26 June 2015

CR2015/002169

**SSD-6882 – PROPOSED INTENSIVE LIVESTOCK DEVELOPMENT - POULTRY FARM, LOTS 1, 41, 42, 44, 45 & 54 DP750898, LOT 1 DP1054064, STURT HIGHWAY (HW14), NARRANDERA.**

Figure 3.4: *BAR Treatment (Extracted from Figure 7.5 from Austroads Guide to Road Design, Part 4A: Unsignalised and Signalised Intersections)*

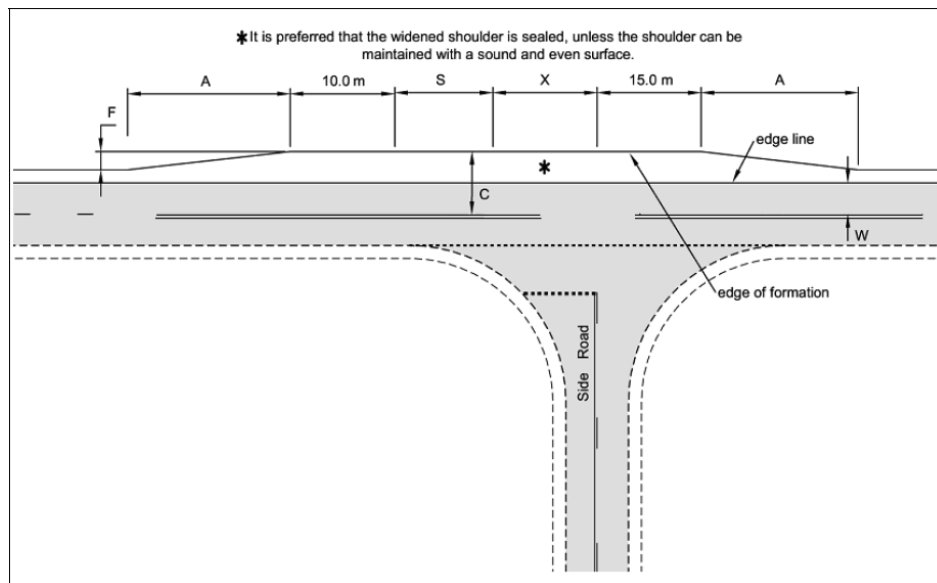
The submitted traffic assessment recommends the construction of a BAR/BAL treatment at the intersection of the new access driveway with the Sturt Highway. As the Sturt Highway is an approved road train route the intersection treatment is to be designed and constructed to the appropriate standards for road train vehicles. The TIA in section 3.5.3 recommends that the intersection with the Sturt Highway be constructed to the standard of a public road intersection and bitumen sealed for a minimum length of 50 metres and that the access road be built to a minimum width of 6.5 metres with a pavement and road surface suitable for B-Doubles. As the roadways and intersections are not intend to be built to accommodate vehicles larger than a B-Double Heavy vehicle into the development site the development should be conditioned to deny any larger vehicles.

4. As a minimum the intersection of the Sturt Highway (HW14) and the proposed access road shall be constructed to the standard of a public road intersection with a Basic Right Turn (BAR) and Basic Left Turn (BAL) intersection treatment in accordance with the Austroads Guide to Road Design for a Road Train route as amended by the supplements adopted by Roads and Maritime Services for the prevailing speed zone on the Sturt Highway.

Proposed Site Access -
BAL/CHR(S) (EDD)

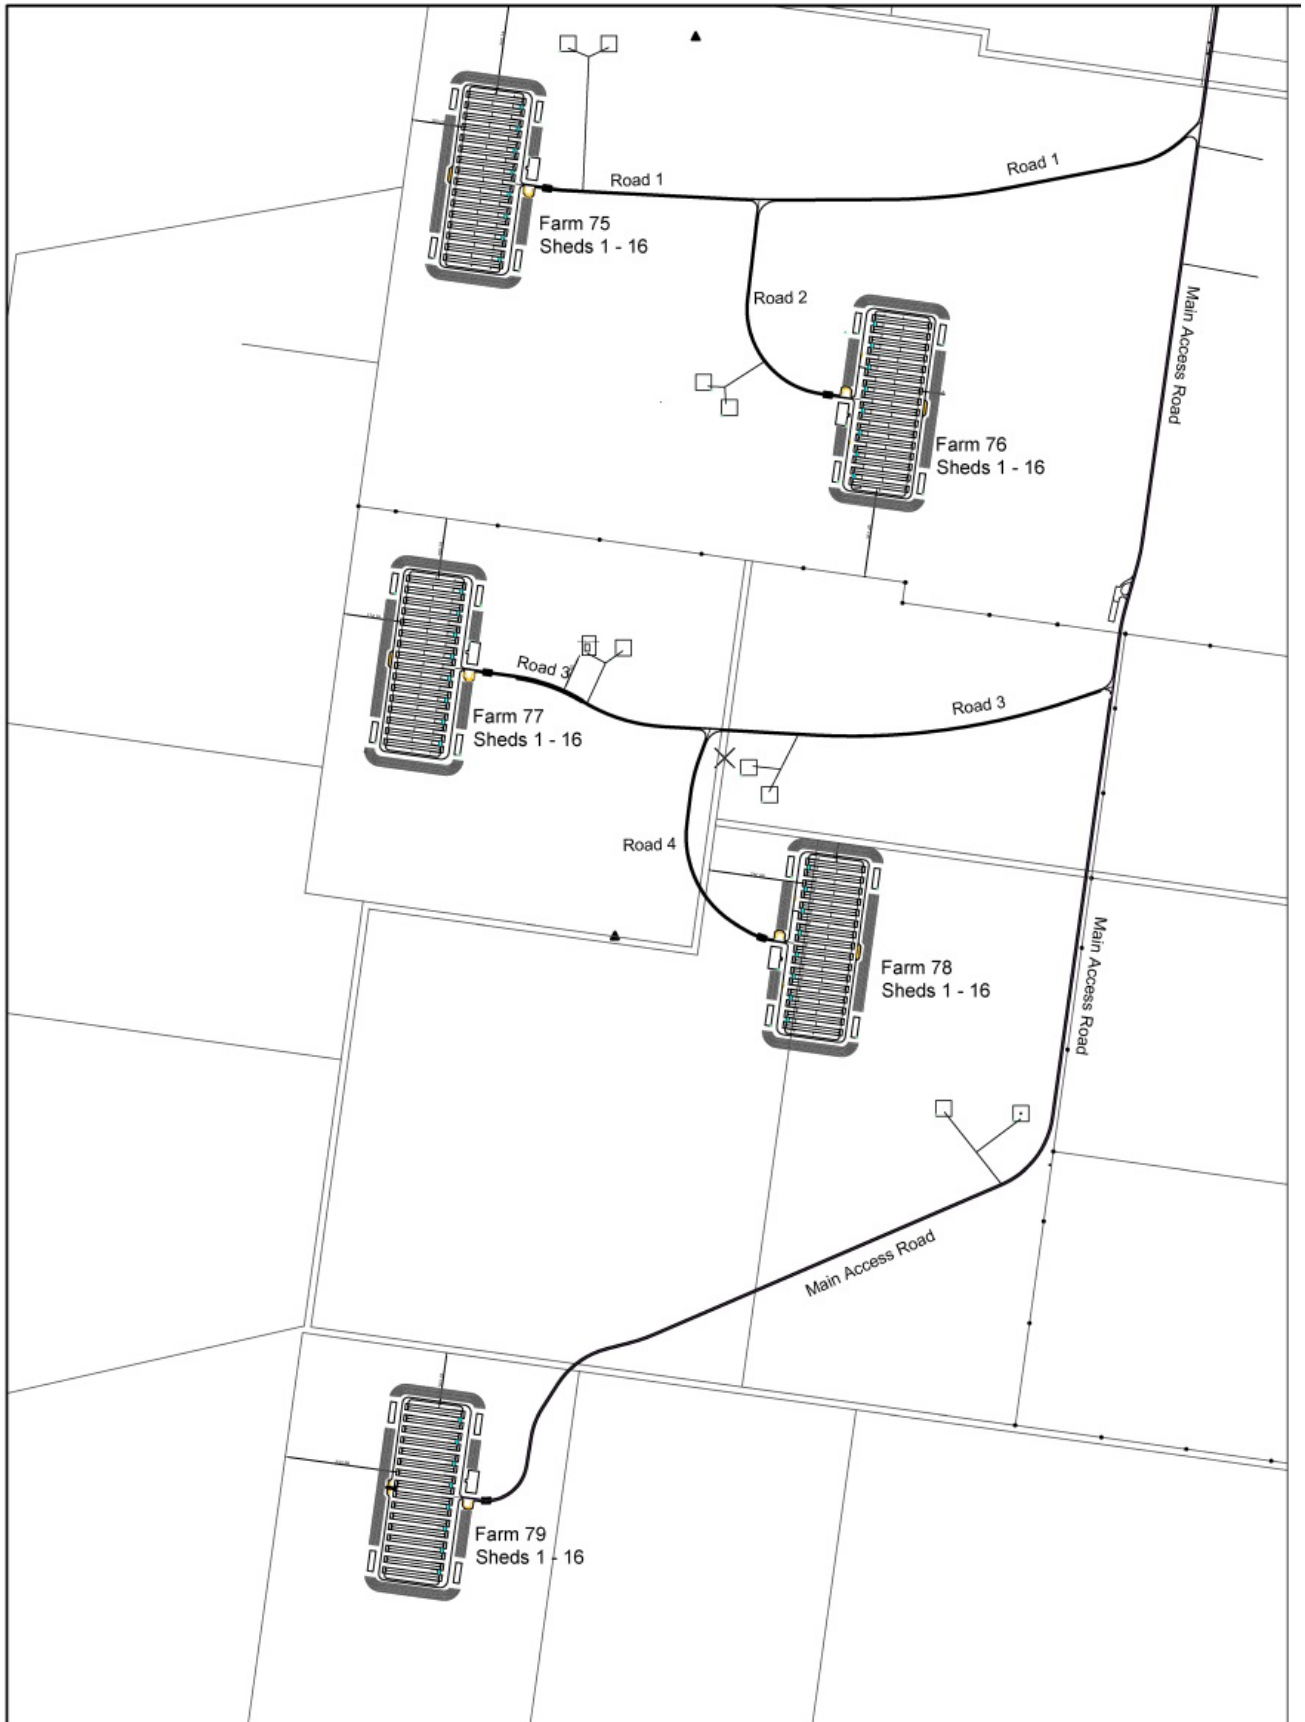
5. The intersection of the proposed access road with the Sturt Highway shall be designed and constructed so that any vehicles entering or exiting the development are not required to cross to the opposing travel lane of the highway in order to perform the access or egress manoeuvre to/from the proposed access road.

6. For at least 50 metres from the carriageway of the Sturt Highway the access roadway shall be constructed perpendicular (or at an angle of not less than 70 degrees) to the carriageway of the highway and with a minimum width to accommodate two way movement for the largest vehicle likely to access the development.

9. The intersection of the proposed access road with the Sturt Highway is to be designed, constructed and maintained to prevent water from proceeding onto, or ponding within, the carriageway of the highway. If a culvert is to be installed and is to be located within the clear zone of the highway for the prevailing speed zone it is to be constructed with a traversable type headwall.

Typical Road Cross from Sturt Highway to first Intersection Ch 0 to Ch 3900

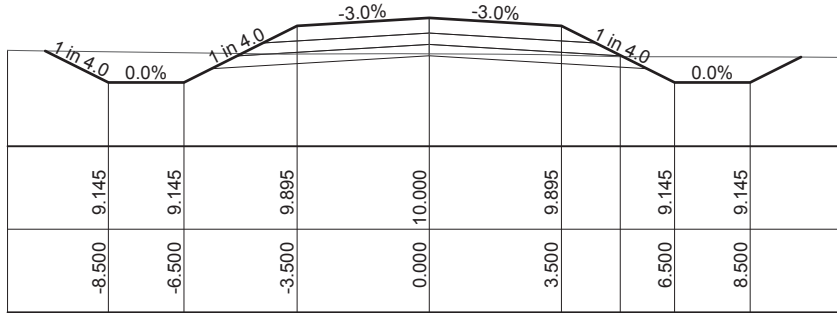
Given the location of the subject development relative to the Sturt Highway and the prevailing winds measures are to be taken to control dust from the internal access road from the Sturt Highway. To address this it is considered that the access road be sealed for at least 50 metres from its intersection with the Sturt Highway. It would be appropriate to require a management plan to be prepared to provide measures to suppress dust generation from the access road to the satisfaction of the Council and Roads and Maritime Services.

8. The proposed access road shall be bitumen sealed for a minimum length of 50 metres from the carriageway of the Sturt Highway. A management plan to provide measures to suppress dust generation from the development site and the access road shall be prepared and implemented to the satisfaction of Council and Roads and Maritime Services.
